Your Ref:
Our Ref: FP/23/10/T
Please ask for:
Mrs J Chapman

9th March 2010

Tree surgery to 2 no. Yew trees
12 Grafton Avenue Felpham

ARUN DISTRICT COUNCIL				
No.	FP	23	10	T

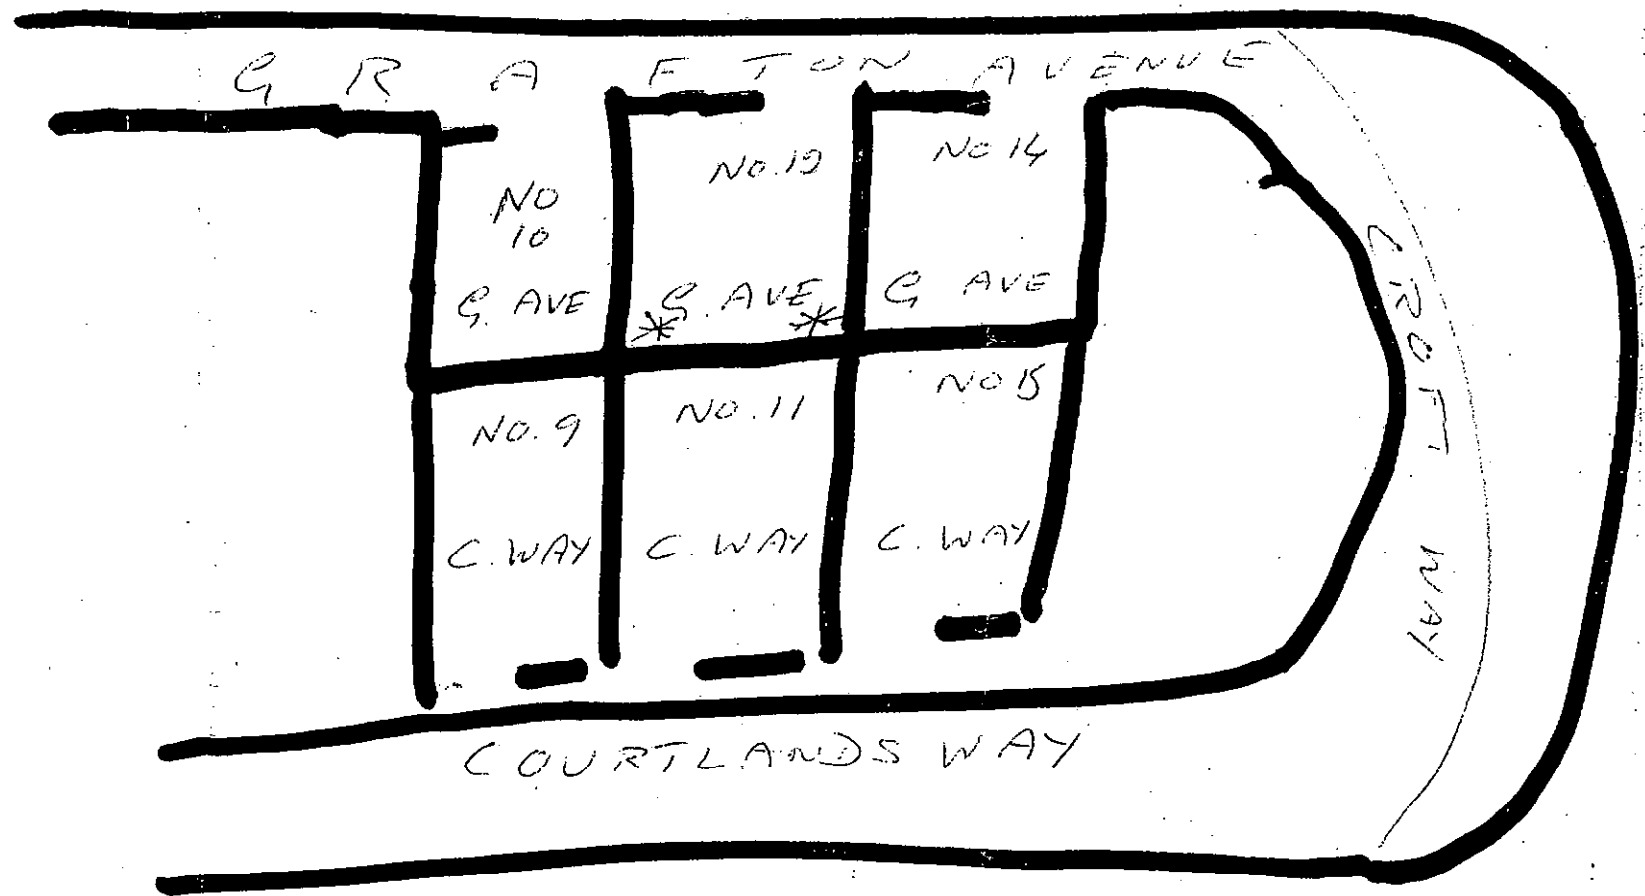
The Tree Warden has visited and recommended: □

Yew tree on right - lift crown above adjoining fence and wall; thin out some limbs back to trunk; top the tree by 1/4. □

Yew tree on left - because of the very poor condition suggest removal of tree and stump ground out.
